RE: CPD Project #1808-026-SUB1 – Responses & Revisions

This letter is in regards to corrections and revisions for the project at 6600 82<sup>nd</sup> Ave SE, 98040. Please review this document with the re-submitted (SUB2) plan set.

2 WEST ELEVATION
 1/4"=1'-0"
 1/8"=1'-0"

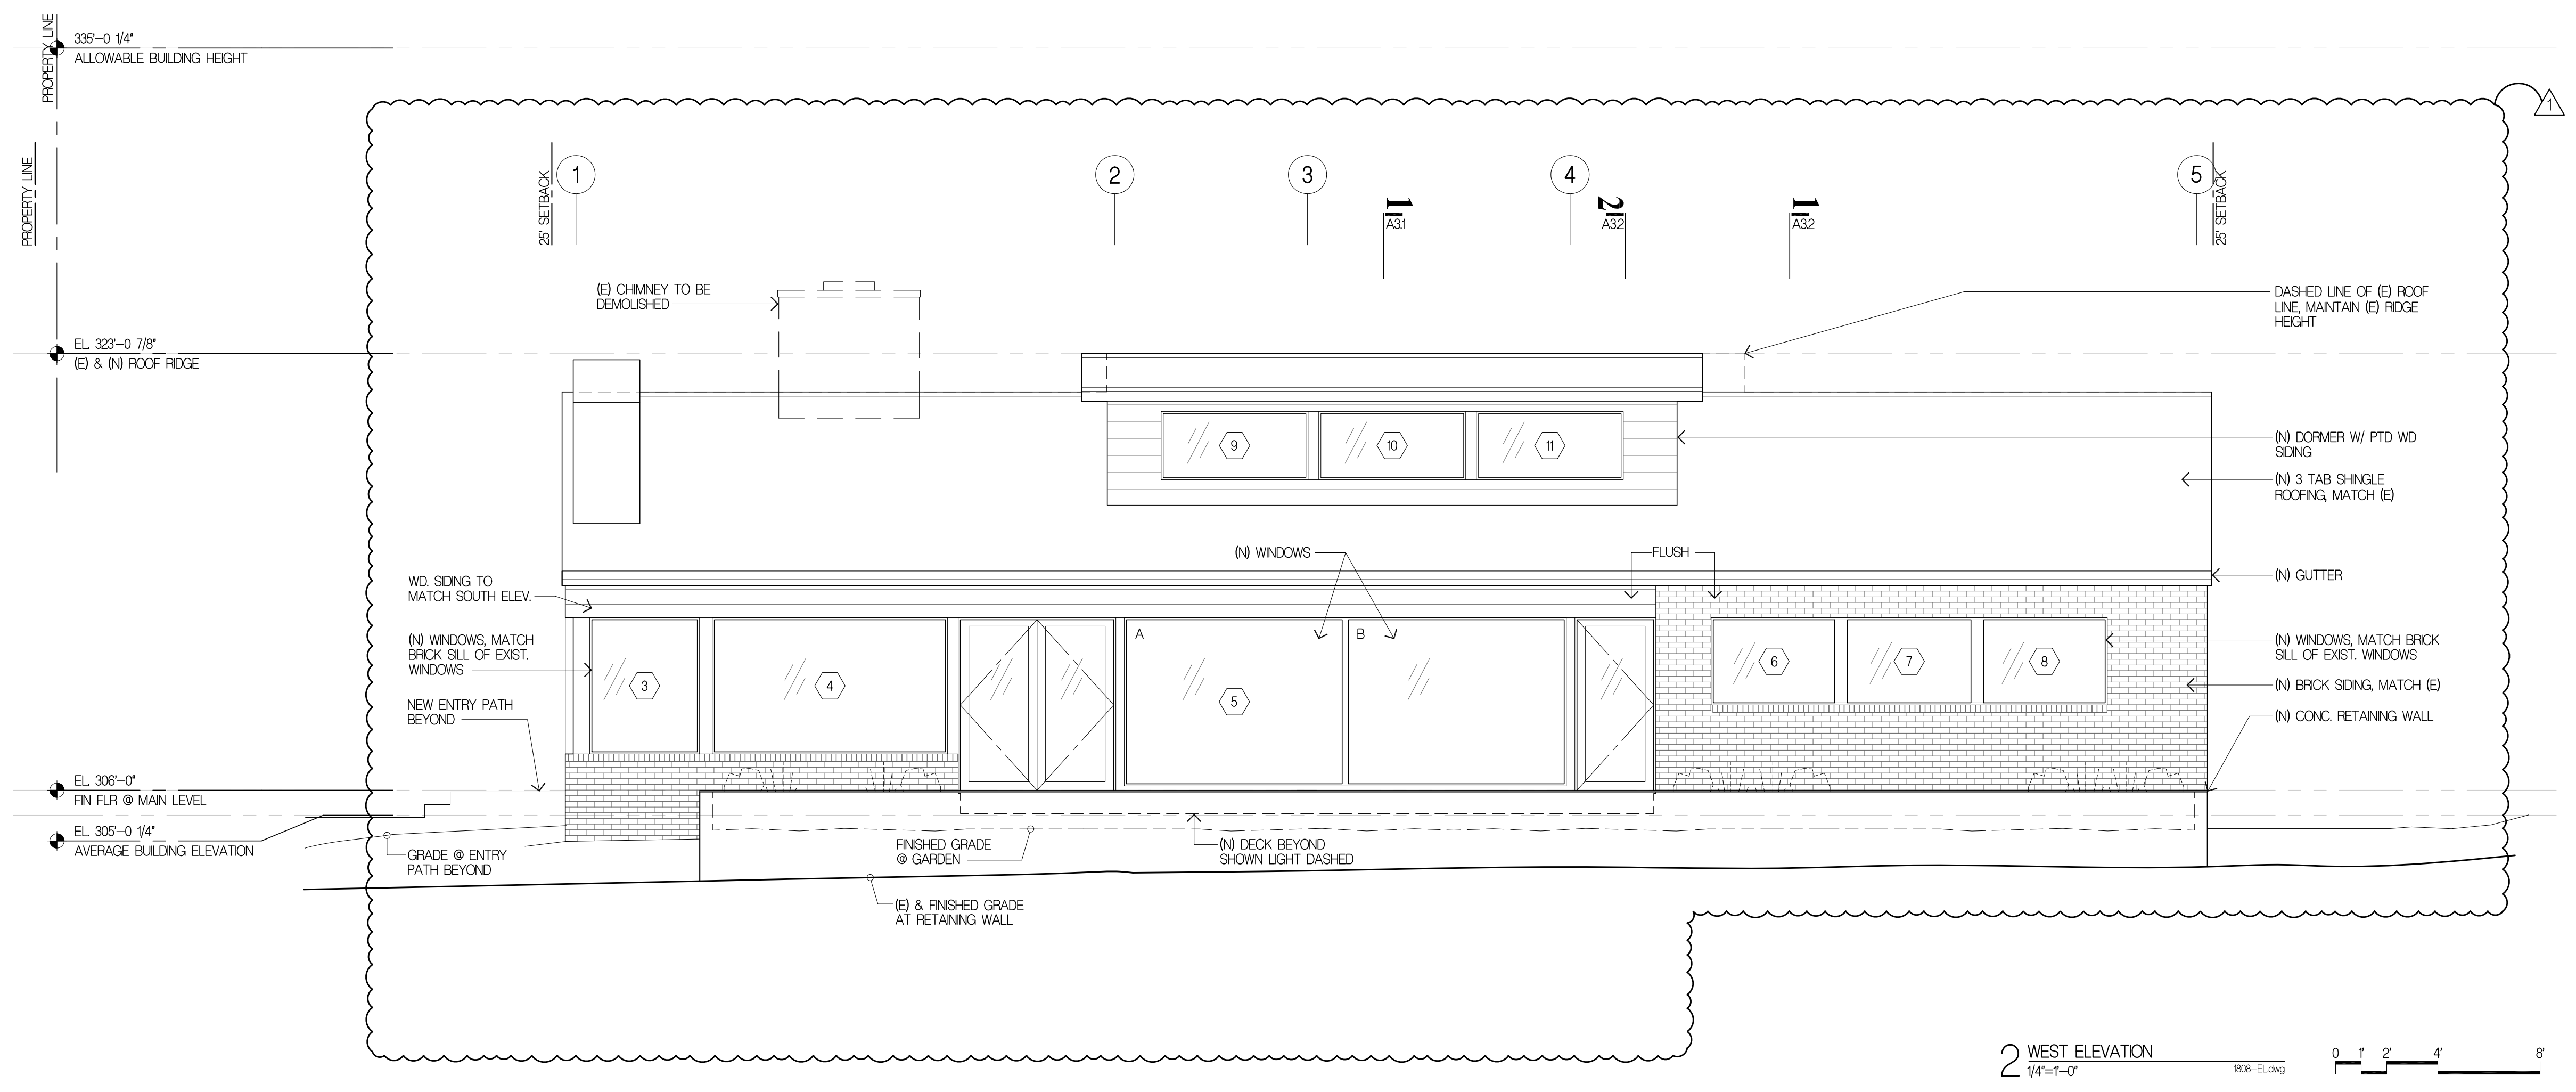
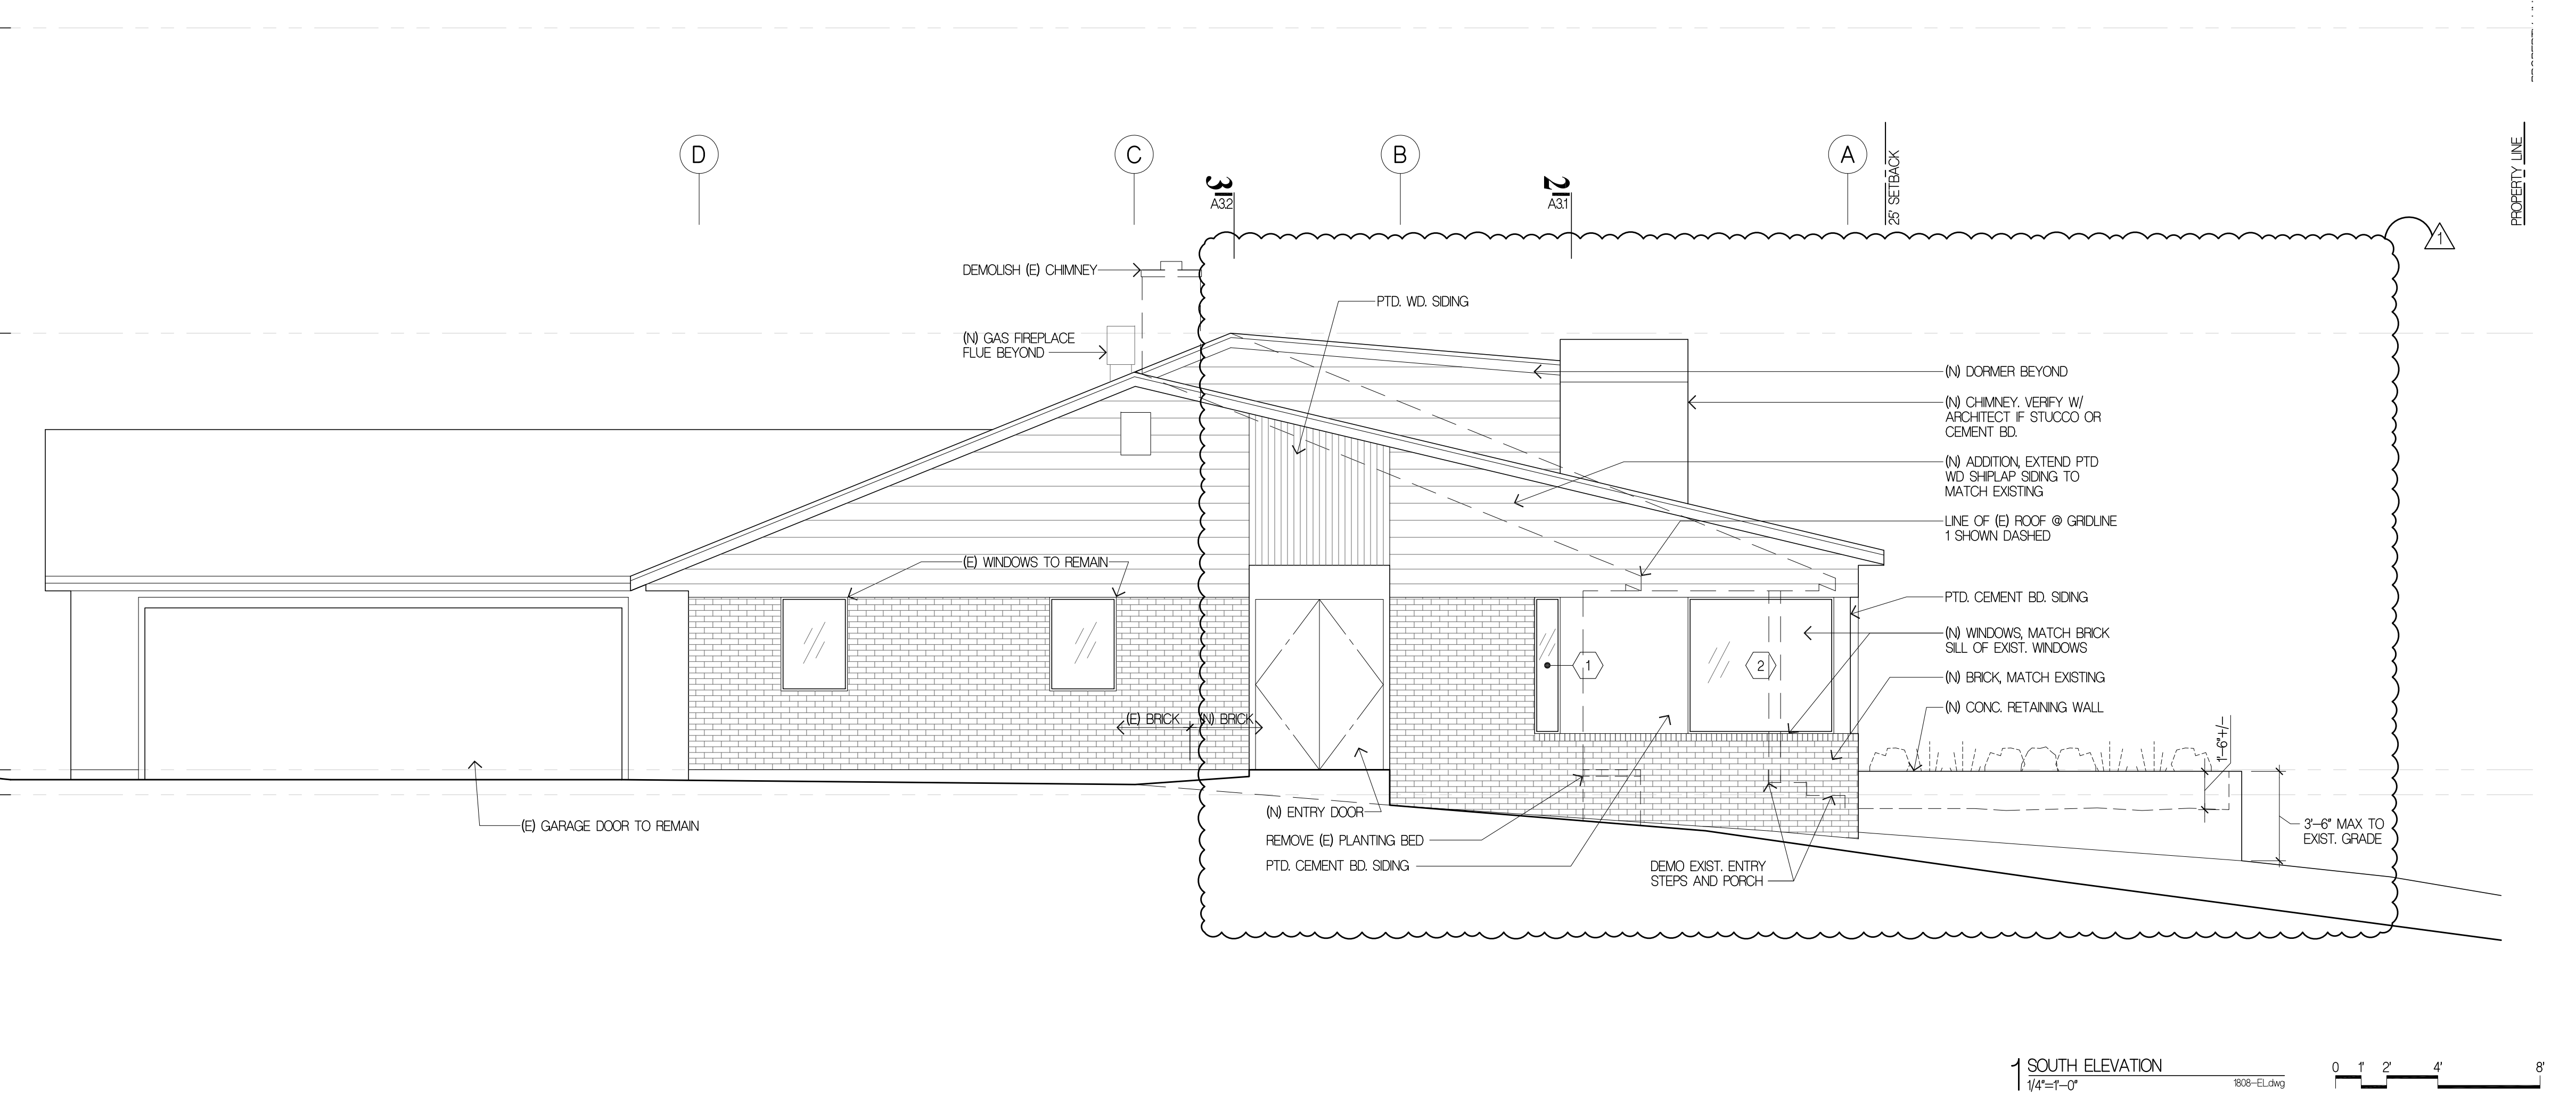
- Elevations updated to reflect revised design

A2.2

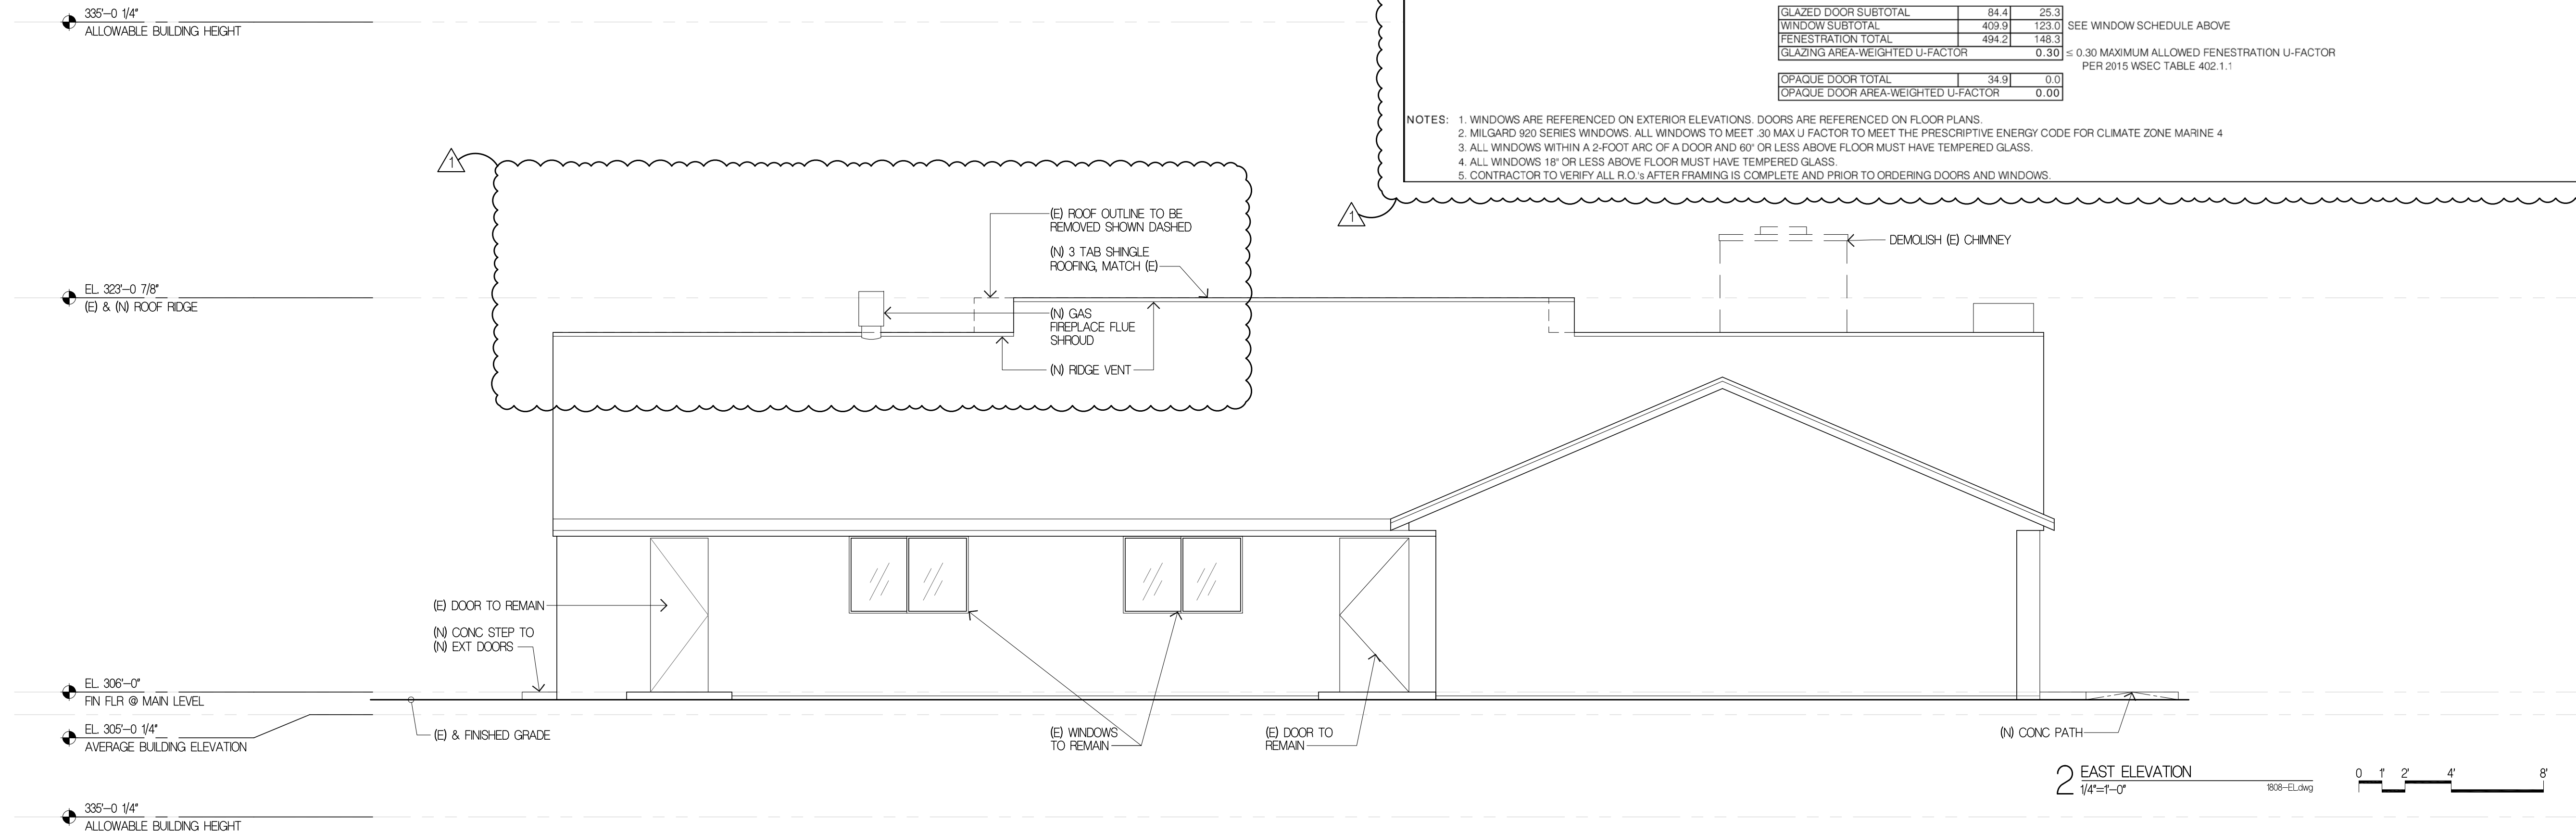
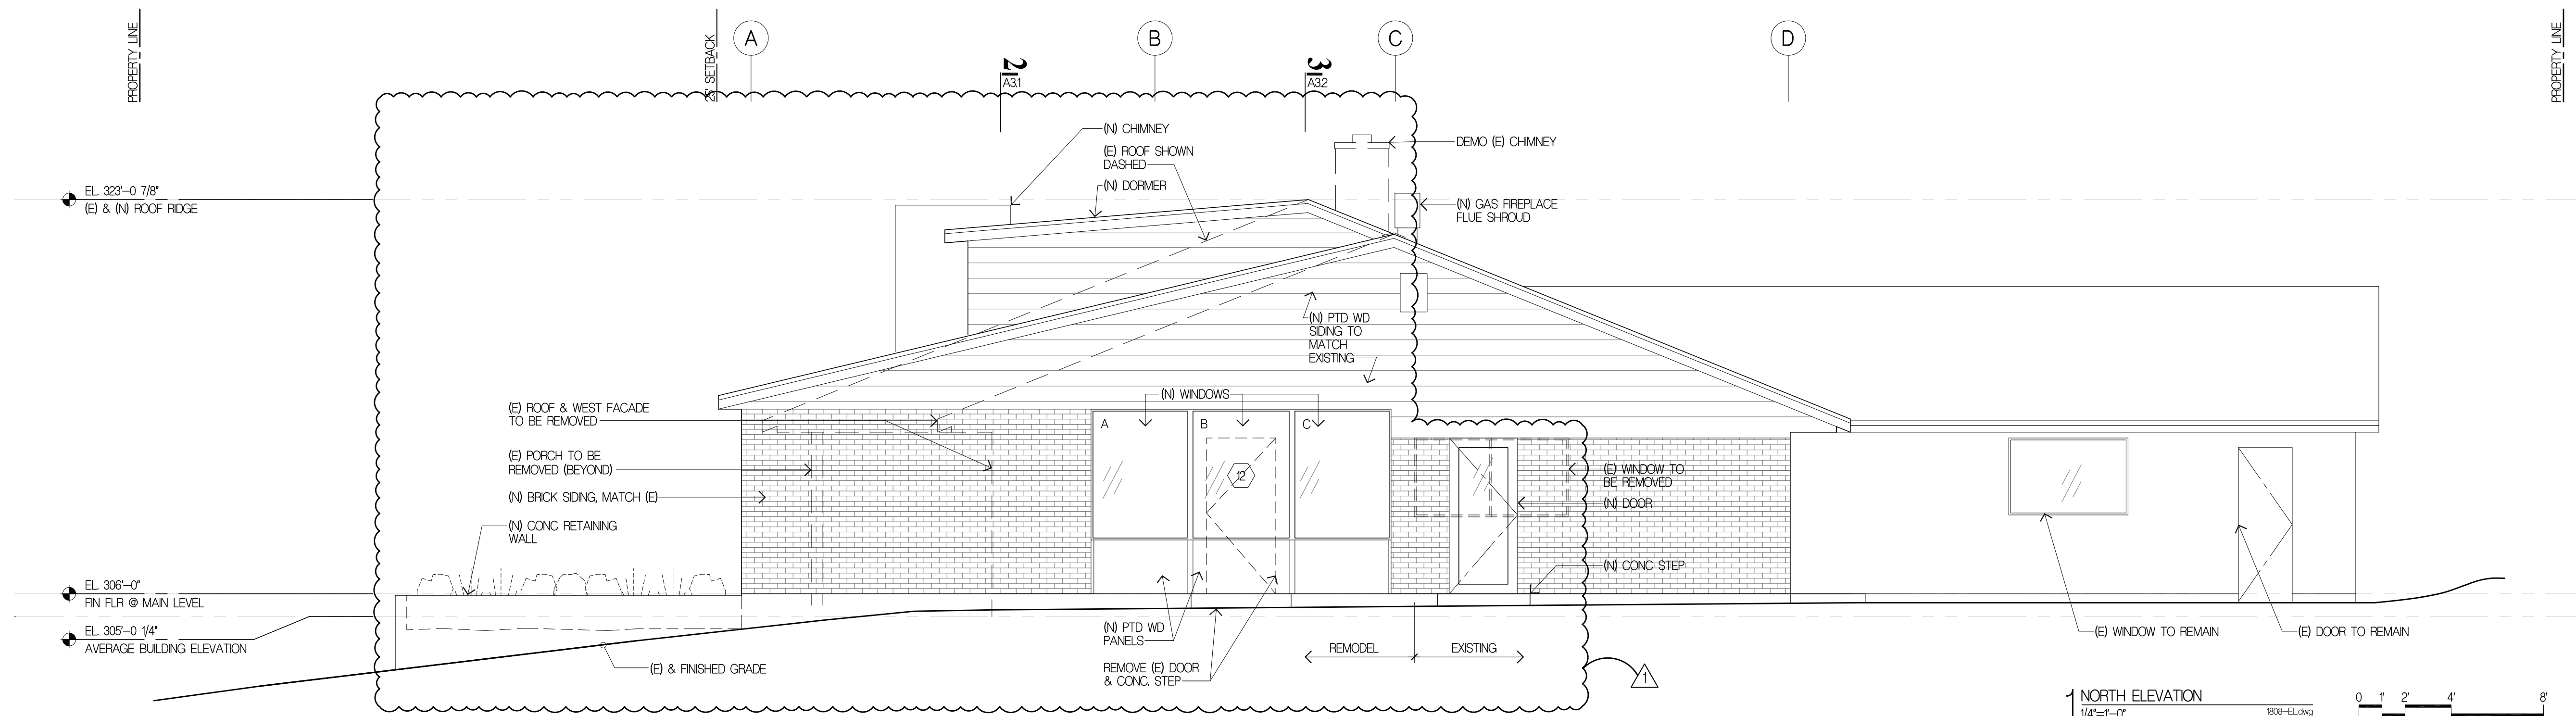
- Elevations updated to reflect revised design
- Window and door schedule updated per revised design
